Re: 70 Anderson St Initial Workshop Feedback-Clarification

At a request of some Bayside Neighbors, I attended the initial workshop last night of the 70 Anderson St new project. I was quite disheartened to see the same shenanigans going on with a Planning board where the impression to the local residents concerns were not taken seriously and a favorable bias to the developer. Last night's workshop illustrated this point.

For 70 Anderson workshop, the developer Jonathon Culley is asking for four waivers all ready knowing the current ordinances. The four waivers are:

**L1.0**

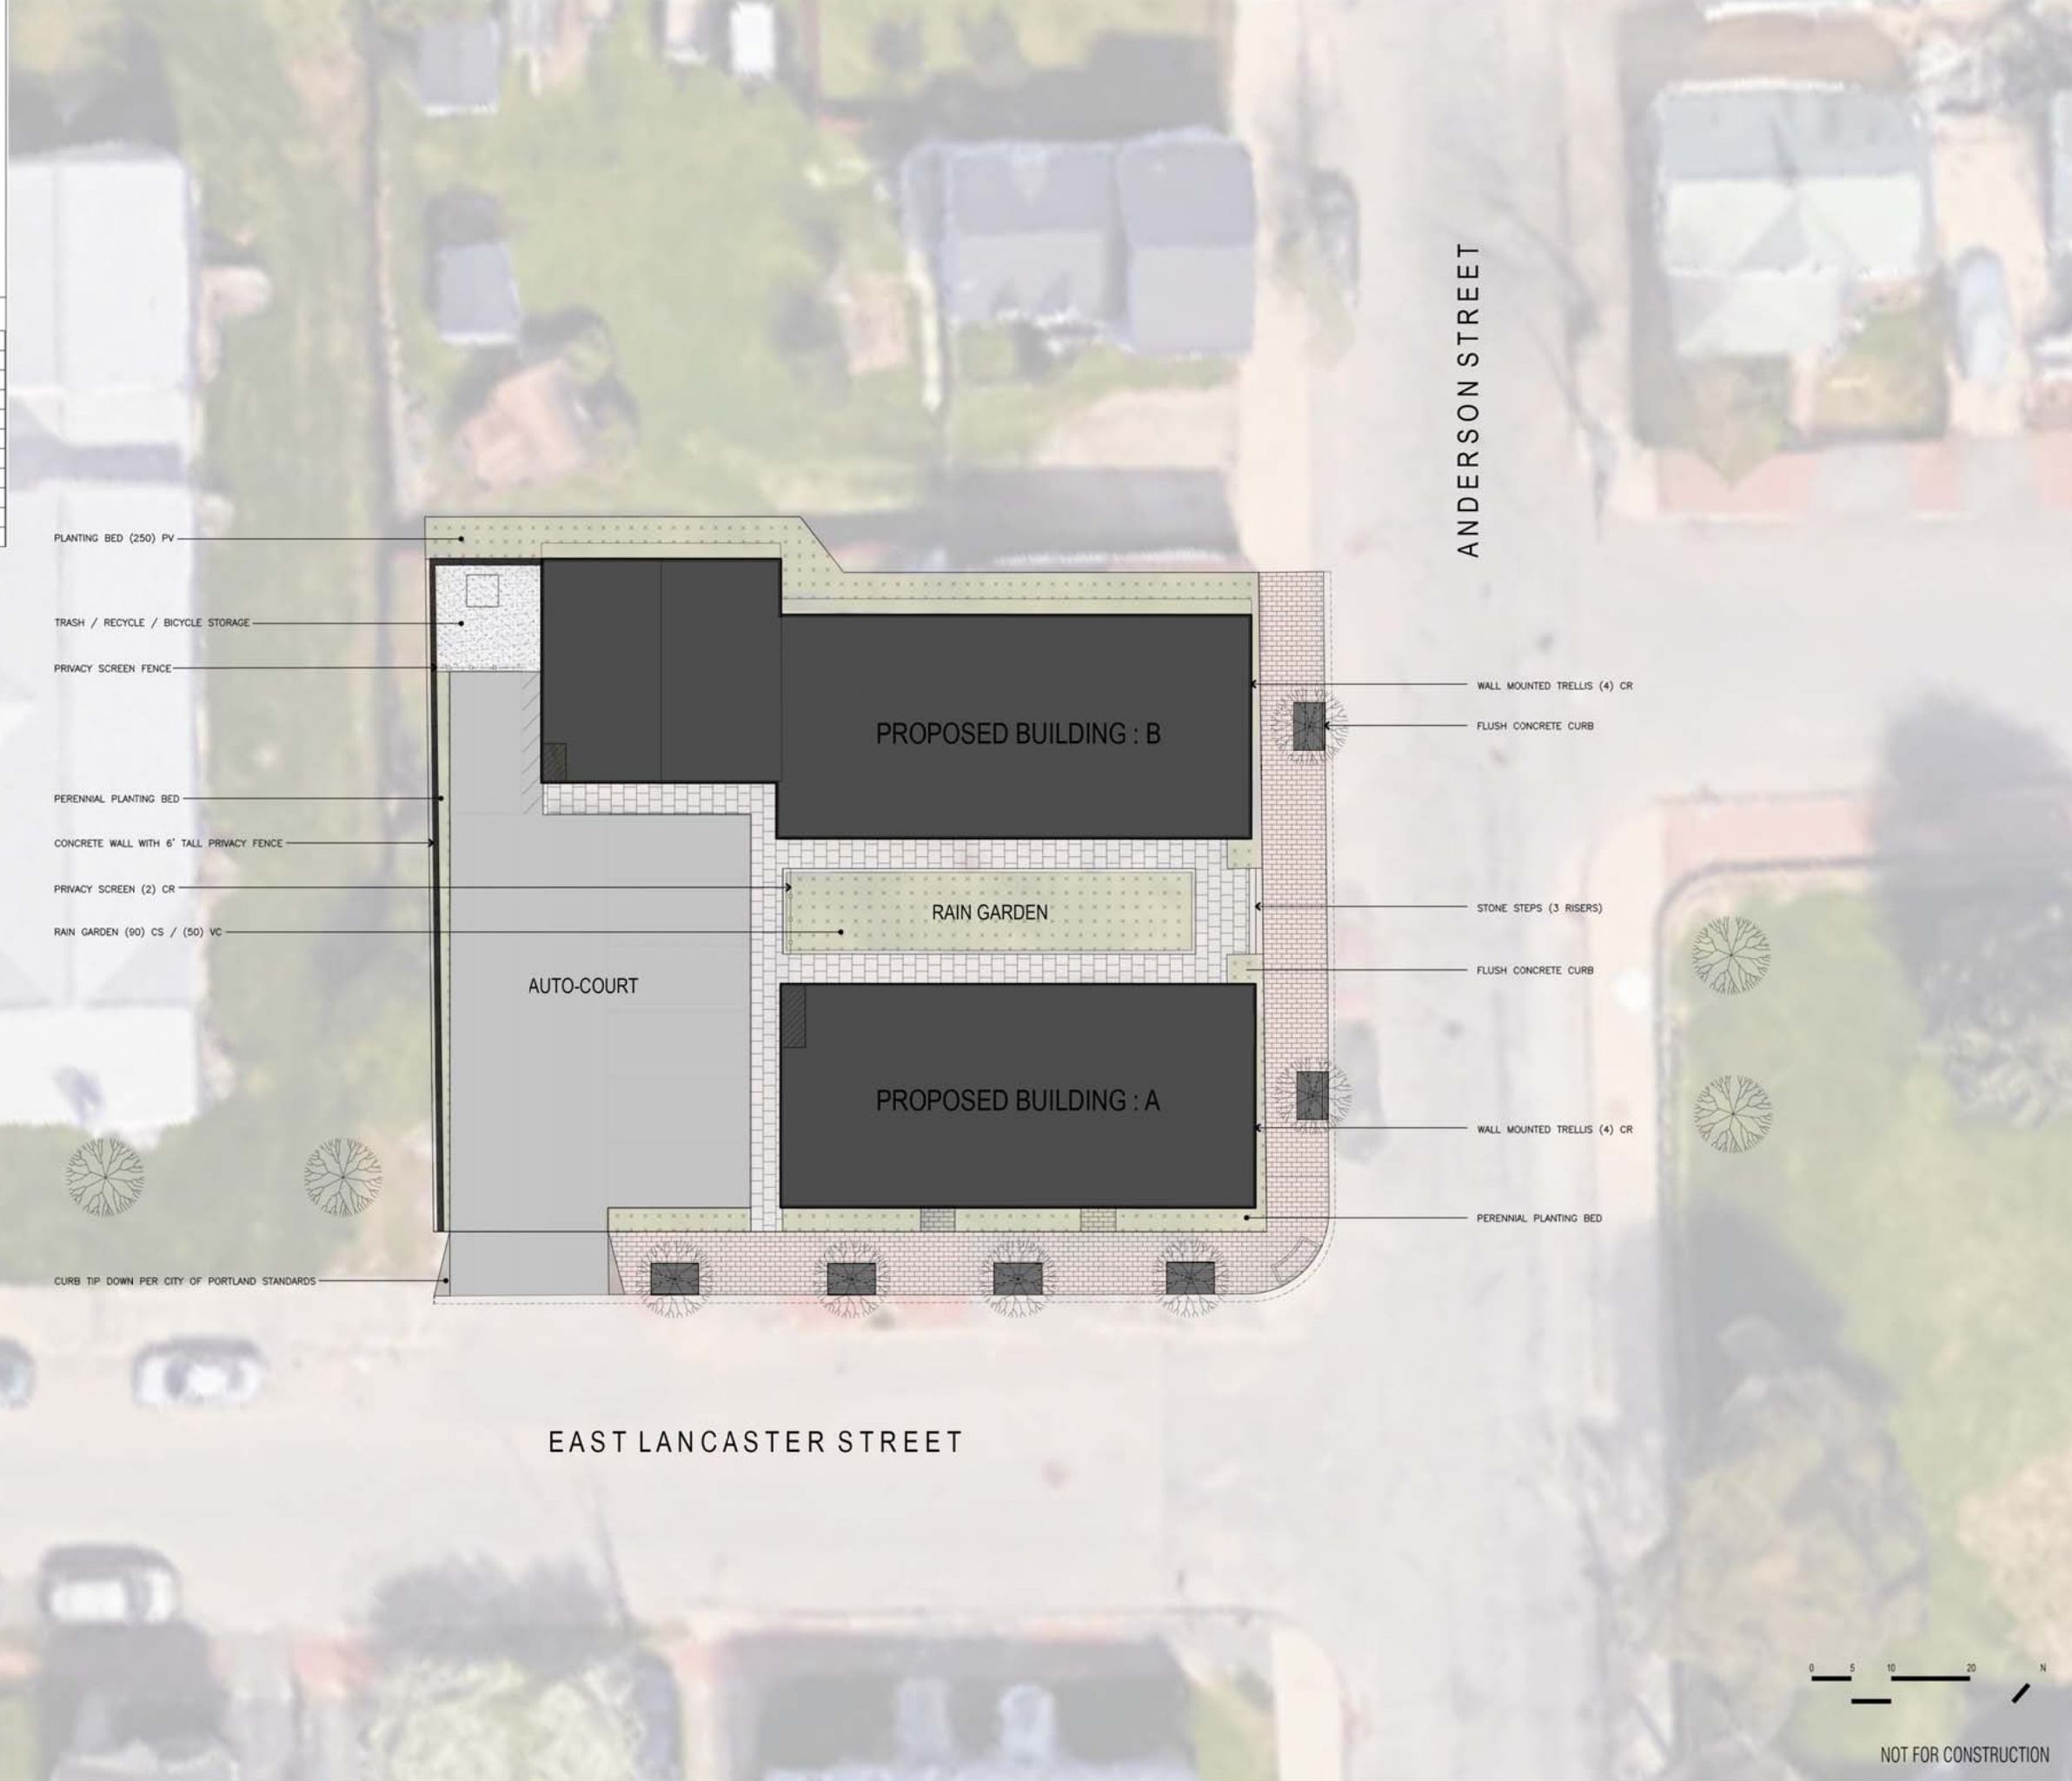
worry, he will have 6 trees between the buildings and he thinks this should qualify for street trees. No, six trees inside a property does NOT qualify as a street tree.

DRAWING NO. **C-10**

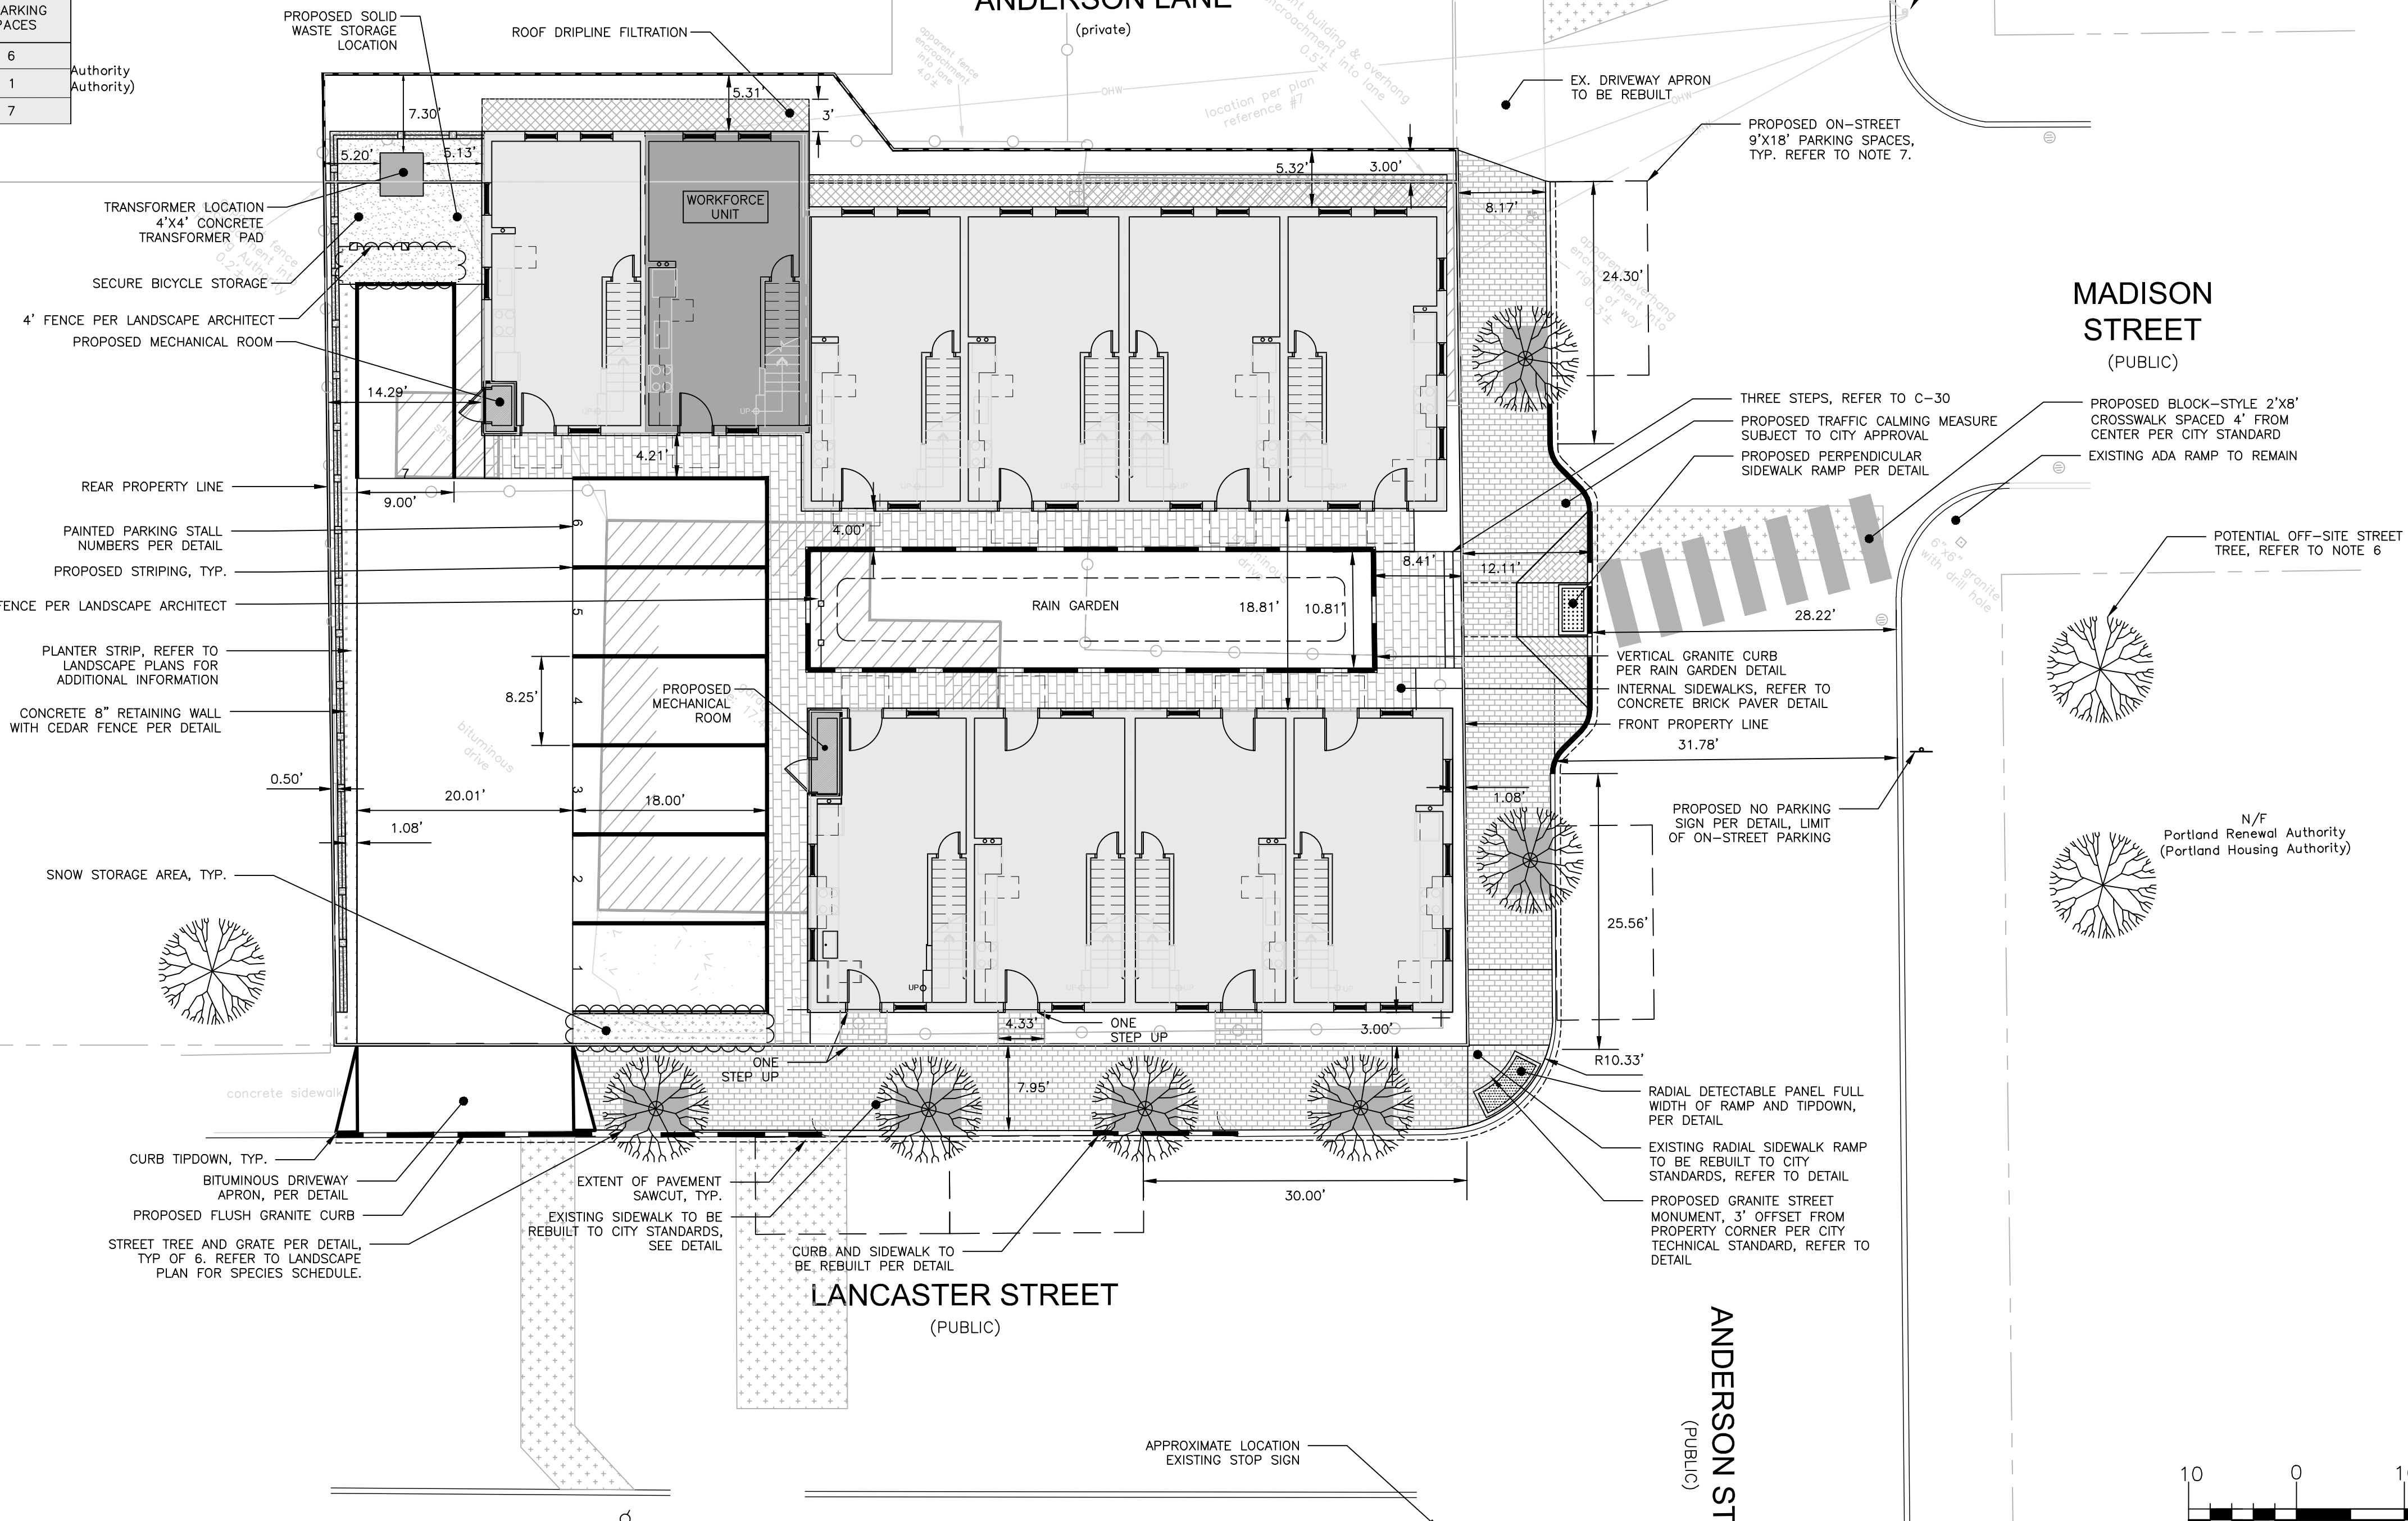
1. The 7 parking spots are only large enough for compact cars. Would families that can afford these 3 bedroom townhouses really have compact cars? More like SUVs.
- Of course he only put in the minimum parking spaces based on the latest changes in the R6 on parking where it is not required to put in parking spots for the first 3 units.
2. The required street trees for this project is 10. He can only fit 4 on Anderson street sidewalk and no street trees on Lancaster St because the sidewalk is too tight because the townhouses are too big. But don't

3. Not enough room for parking landscaping due to the tight spaces.
4. Lack of aisle way for entrances.

1. The adjoining neighbor who wants to put solar panels on roof and Culley's design could potentially block the sun for this neighbor.
2. The adjoining neighbors concern of the abatement of these buildings and how it will affect his children and the garden where he grows his vegetables.
3. Yet once again concern of affordable housing of Jonathan Culley and the minimum requirement of having one affordable house on this site based on the Ensure Workforce Housing Fairness Act.
4. The 4 waivers which the Planning Board didn't seem to be concerned with and the impression that they will be waived quite easily these waivers for not having properly sized parking spaces, lack of parking landscaping, and the lack of street trees.
